SUNNICA ENERGY FARM DCO EXAMINATION

WRITTEN REPRESENTATION

ANNEX A - LANDSCAPE AND VISUAL IMPACT

Landscape and Visual Issues

Drawing Title  
**FIGURE 10-10  
 LOCAL LANDSCAPE  
 CHARACTER AREAS**

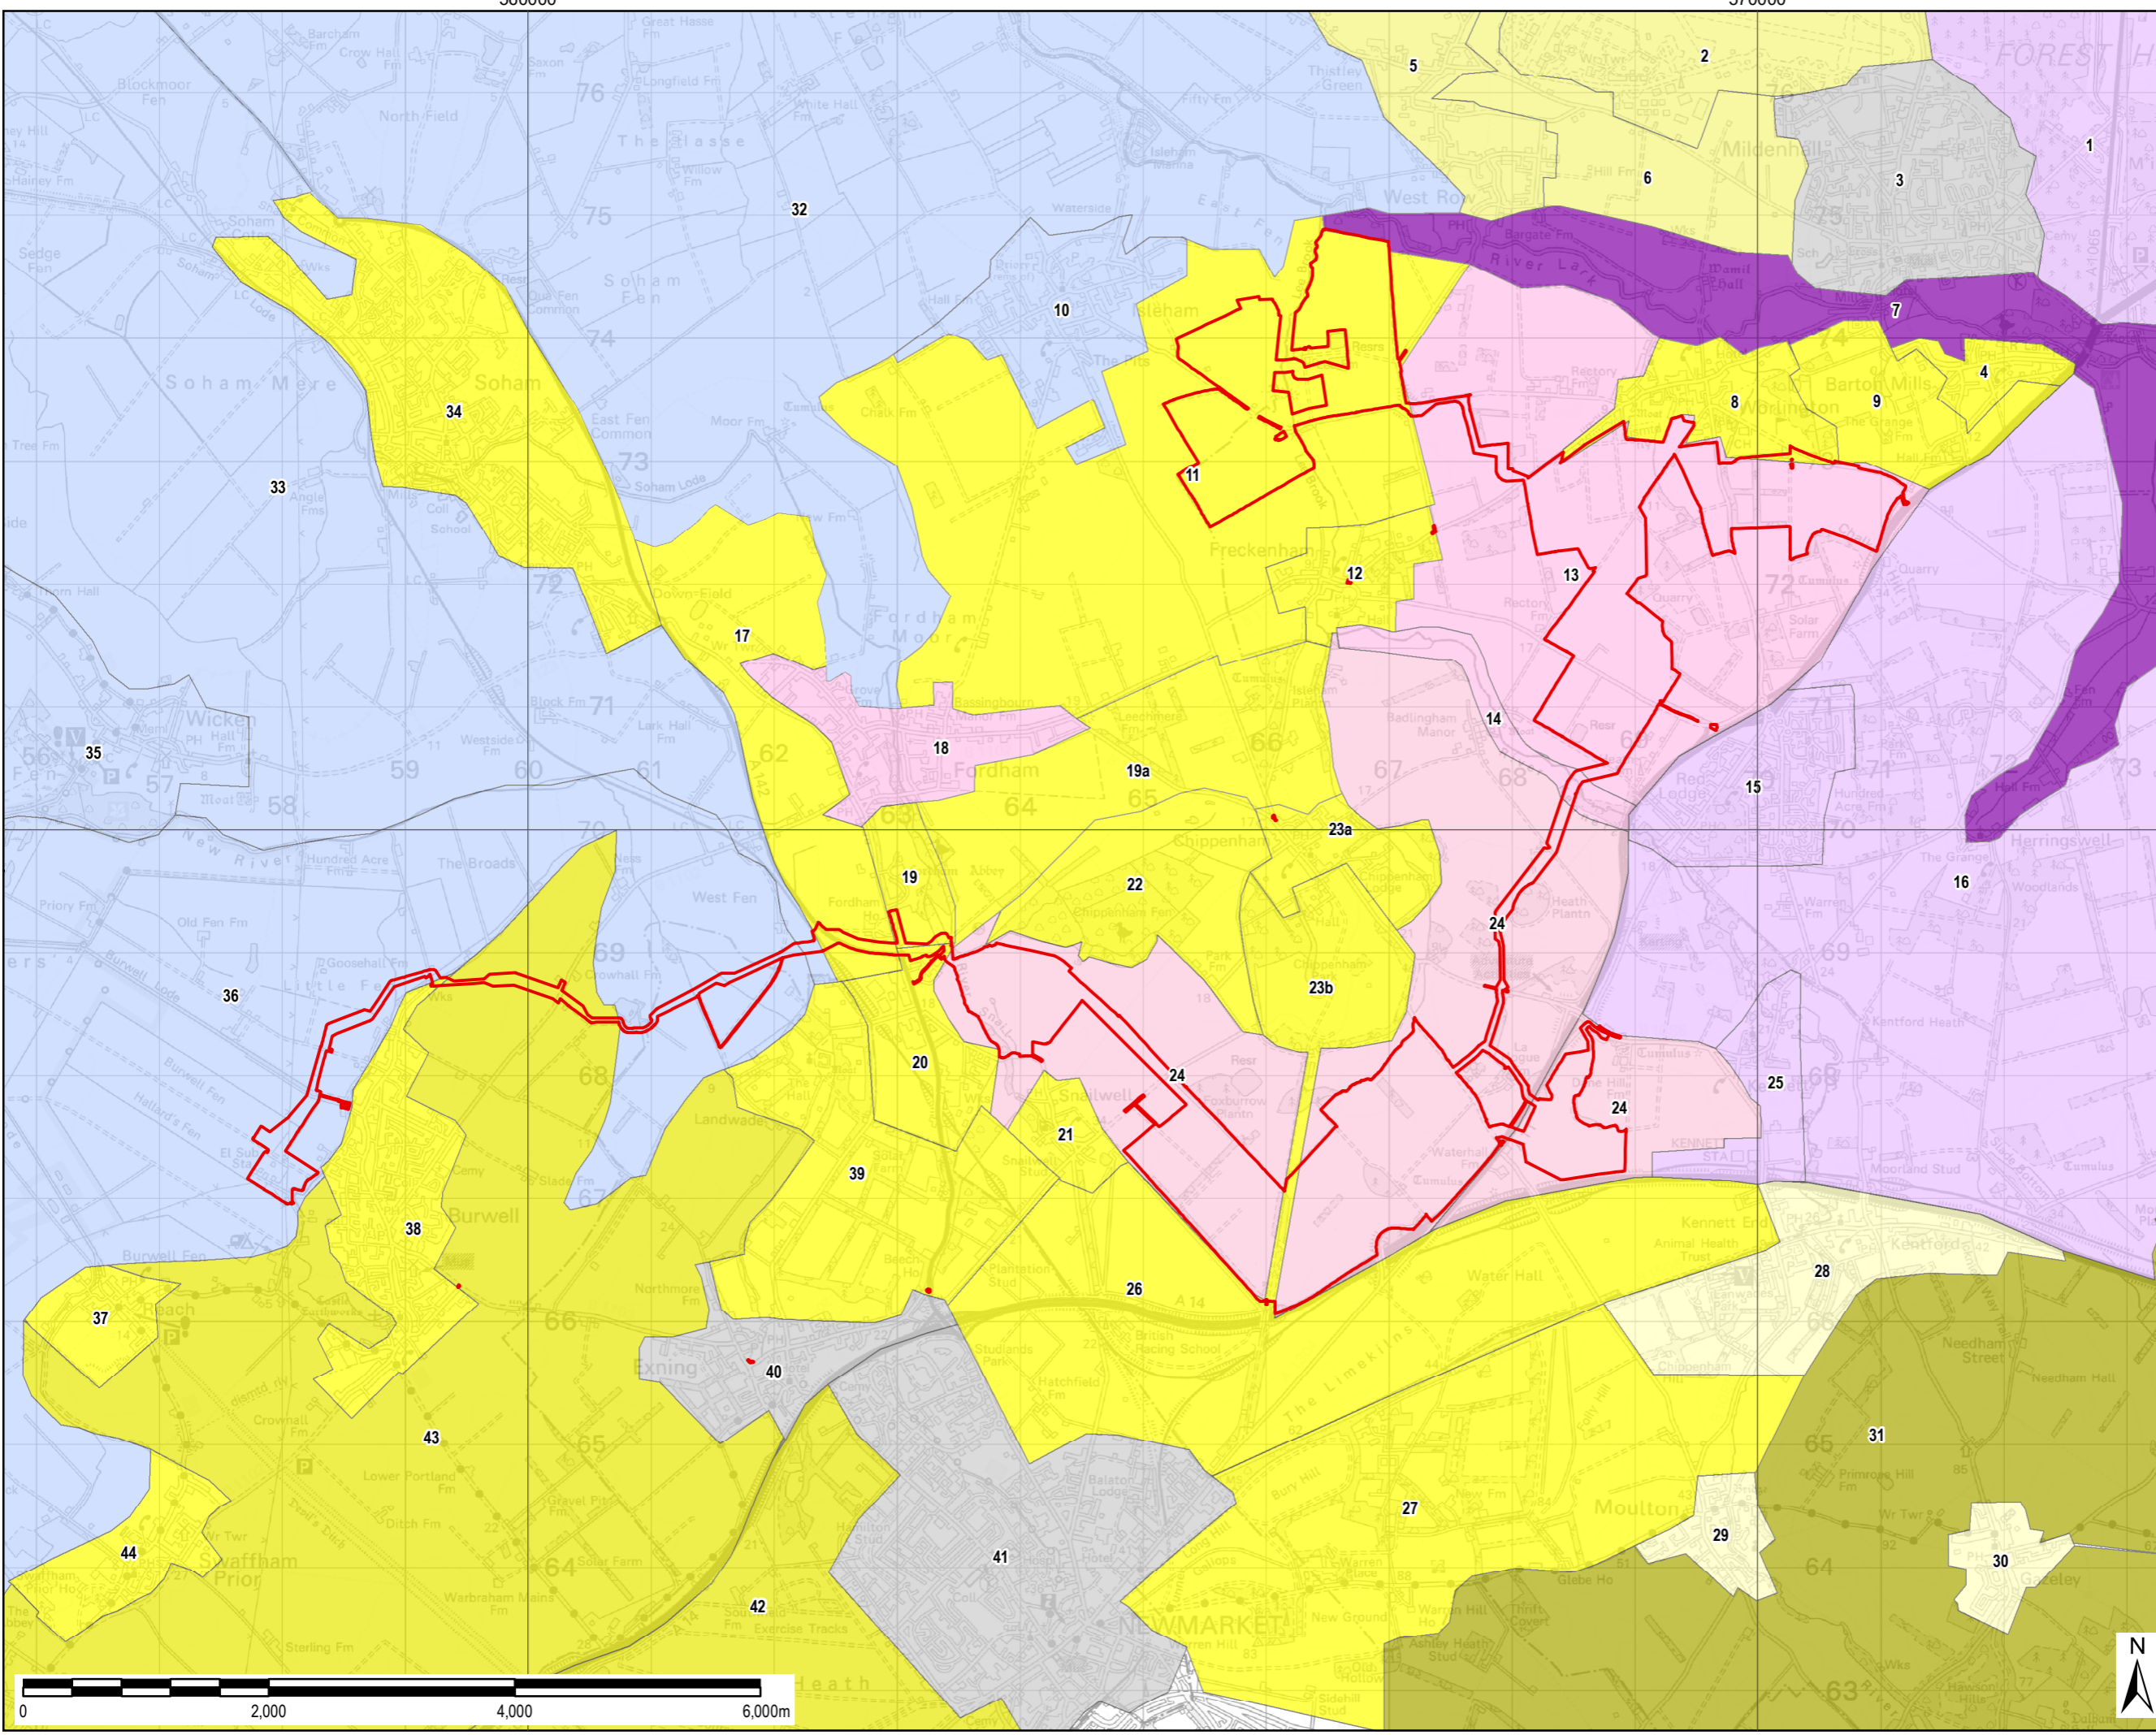
- 1.32 Notwithstanding the above, the LVIA finds that the local landscape in which Sunnica East Site B is located (LLCA 13) and in which Sunnica East Site A & Sunnica East Site B are located (LLCA 24) would experience a **major adverse** landscape effect at Year 1 (**Figure 21**). This is the highest level of effect.

- 1.33 Elsewhere the LVIA has underestimated the level of effects and overestimated the effectiveness of mitigation planting e.g., in the finding that the landscape in which Sunnica East Site A is located (LLCA 11) would only experience a **minor adverse** effect at Year 1.
